Martins Creek Quarry (SSD-6612) – Review of Response to Submissions Report

I refer to your e-mail dated 19 November 2021 in which the Planning and Assessment Division (P&A) of the Department of Planning, Industry and Environment (the Department) invited Biodiversity and Conservation Division (BCD) to provide advice in relation to the Martins Creek Quarry project (SSD 6612).

BCD has reviewed the Response to Submissions Report, including relevant appendices, in relation to impacts on biodiversity (including matters of national environmental significance [MNES] under the *Environment Protection and Biodiversity Conservation Act 1999*) and flood risk assessment.

Figure 3: Conceptual Rehabilitation Plan

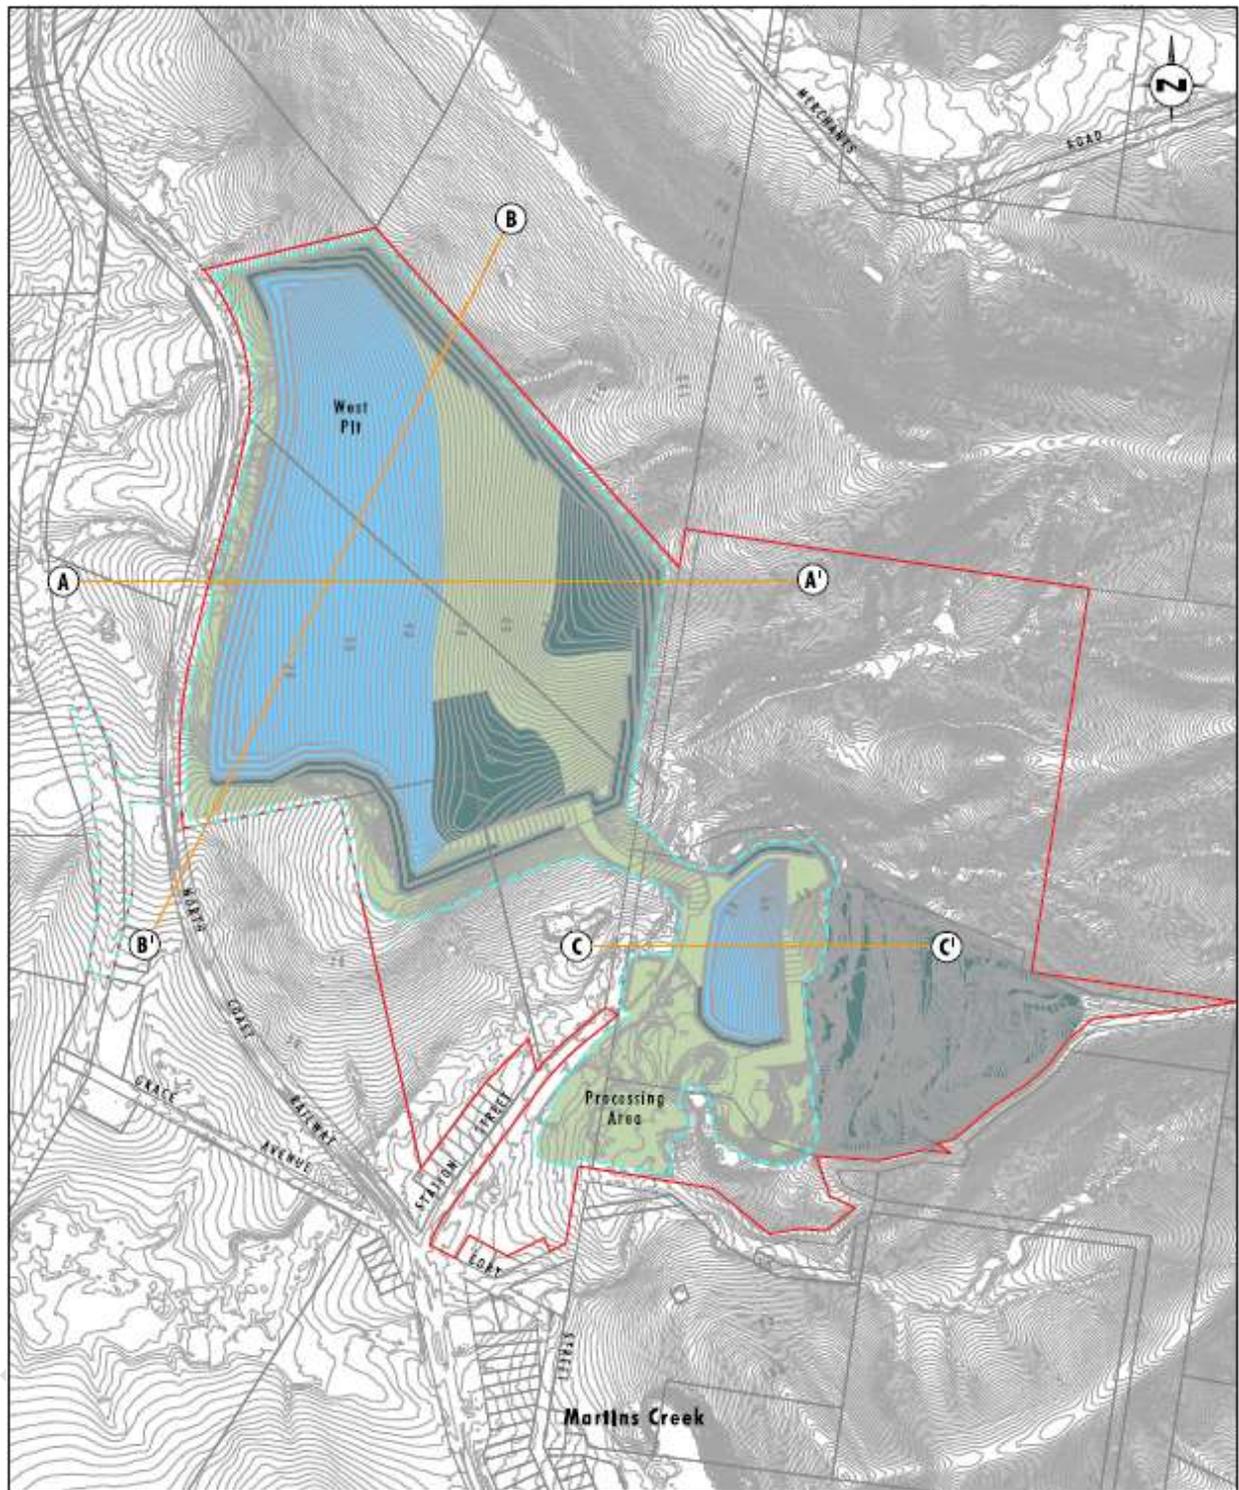
Figure 5.1 of the rehabilitation strategy indicates that two permanent voids will remain in the rehabilitated landscape. The west pit void is very large in size and the Surface Water Impacts Assessment indicates it will take approximately 22 years to fill. The smaller east pit is estimated in the report to take 8 years to fill. This means that water from within the catchment will not flow into the downstream waterway for the full duration of the time taken to fill the remaining voids. During operation, portions of this water would be returned to downstream areas via pumping however pumping ceases when the quarry is decommissioned. These impacts will be exacerbated by ongoing evaporation loss from the voids.

Loss of water to the downstream ephemeral waterway is likely to have an impact on the riparian vegetation which has not been considered.

In addition, the manner of discharge to the downstream waterways in a flood event will also change post-rehabilitation. Once the storage fills discharge will be via weir flow to the receiving environment with unknown effect on downstream flooding and erosion. No assessment has been made on the changed hydraulic behaviour post rehabilitation.

The hydraulic impacts of inclusion of large mine voids in the final landform on riparian health and downstream ecosystems is to be assessed prior to approval, not deferred to rehabilitation assessment. The report prepared for item 4 above may form a baseline condition report. Any EEC in the downstream riparian area is to be identified. Removal of water may have additional biodiversity impacts and further offsets may need to be negotiated to compensate for loss of vegetation post quarry rehabilitation. An action plan is to be developed to determine how riparian condition will be protected in the long term flow removal period following rehabilitation.

Impact on downstream flooding and streambank erosion are to be assessed by suitable hydraulic modelling for the post void filling period due to the concentration of flow and changed flow regime. Assessment of likely water quality and the potential for pollutant mobilisation in the post rehabilitation flow through scenario is to be determined together with a monitoring regime to ensure commitments made are adhered to.
